Our ref: ECM 8399344  
Contact: Gemma Bennett  
Telephone: (02) 4732 8285

18 October 2018

**Notice of exhibition - Snack Brands Warehouse and Distribution Facility  
(SSD 9429) 585-649 Mamre Road, ORCHARD HILLS NSW 2748  
(Lot 2171 DP 1153854)**

Landscape Sections - AA & BB

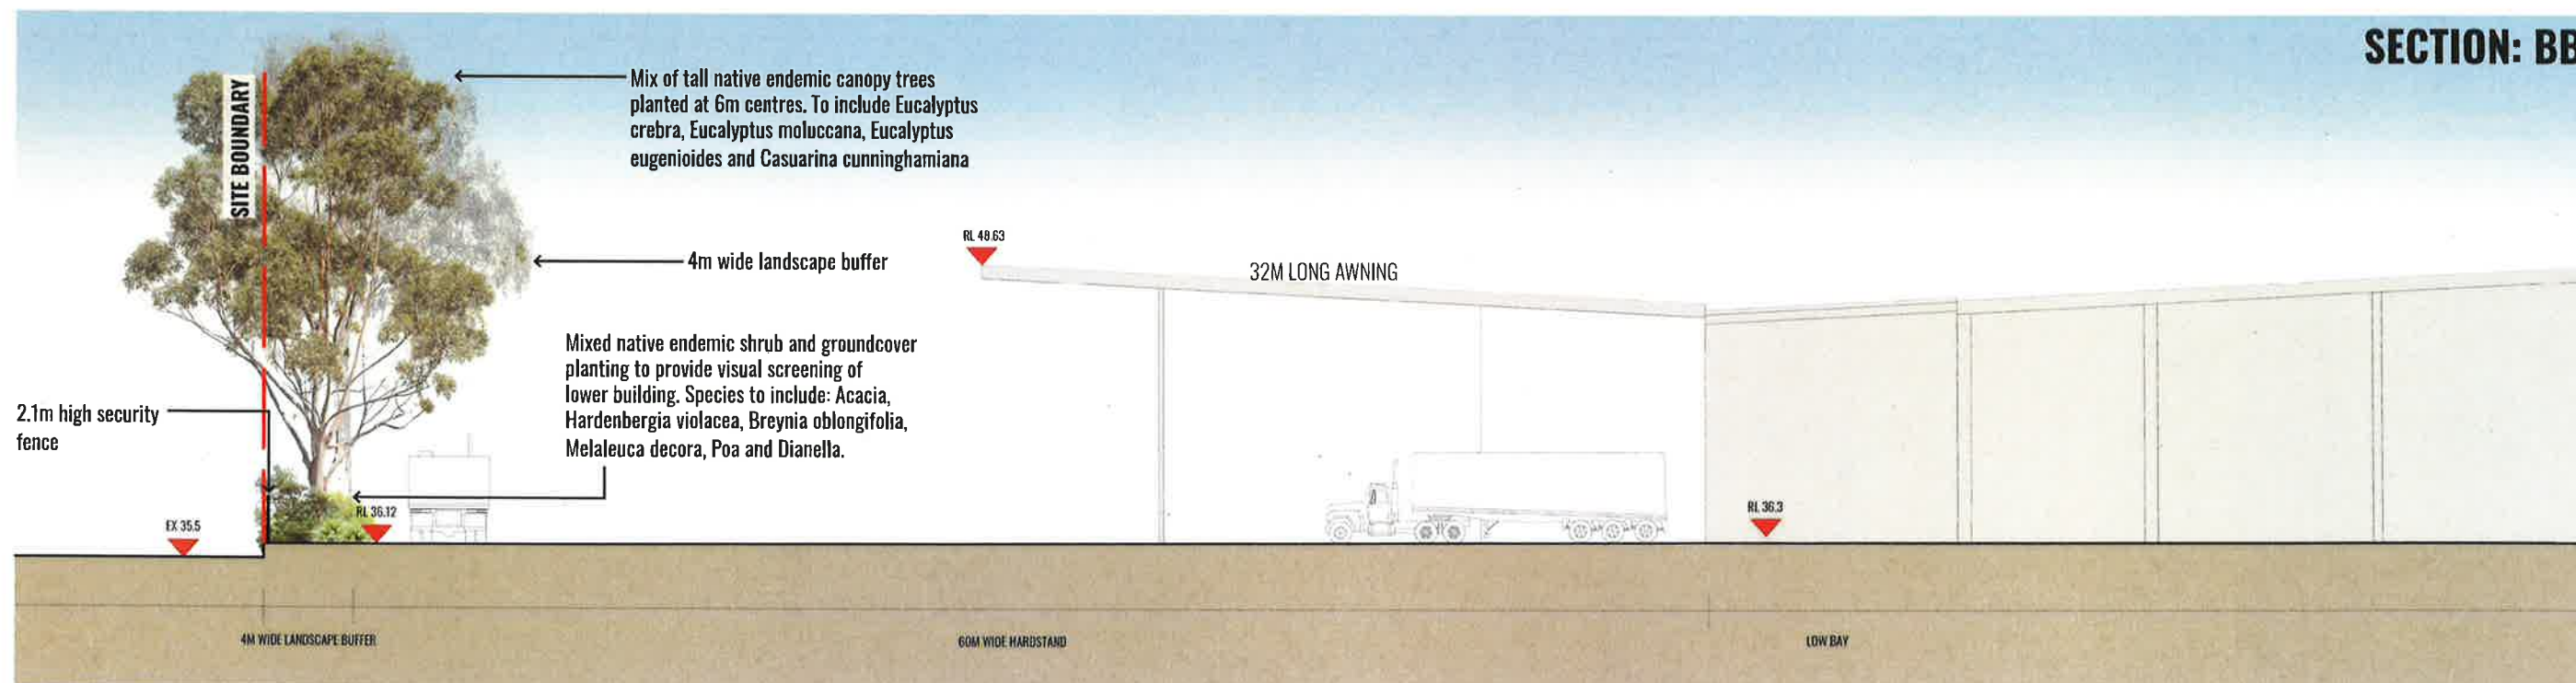
The location of the landscaping near the corner must be considered in context of any future signalisation of the intersection and traffic or business related signage. It should be noted that no detail on external pylon signage has been indicated on the plans. The width of the landscaping buffer narrows at the south eastern corner of the Landscape Stage 1 Plan (by Geoscapes, drawing no. SSD-01, issue C, dated 31-07-18) and should be designed to enable a full 10m landscaping width on the corner.

The selection of native species is considered appropriate. Informal planting is recommended rather than any design using formalised rows. Mid storey planting (shrubs and trees) is required as well as the ground covers and trees in order to provide any effectiveness to the desired screen planting. It is suggested that an earth mound should be incorporated into the landscape buffer in order to raise the height of the vegetation and assist in screening the bulk of the development. This is consistent with the earth mound and landscaping established on the opposite side of Mamre Rd at Erskine Business Park.

The landscape buffer should continue across the entire frontage of both the stage 1 and 2 sites in order to maximise screening of the development, particularly when approaching on Mamre Road from the north.
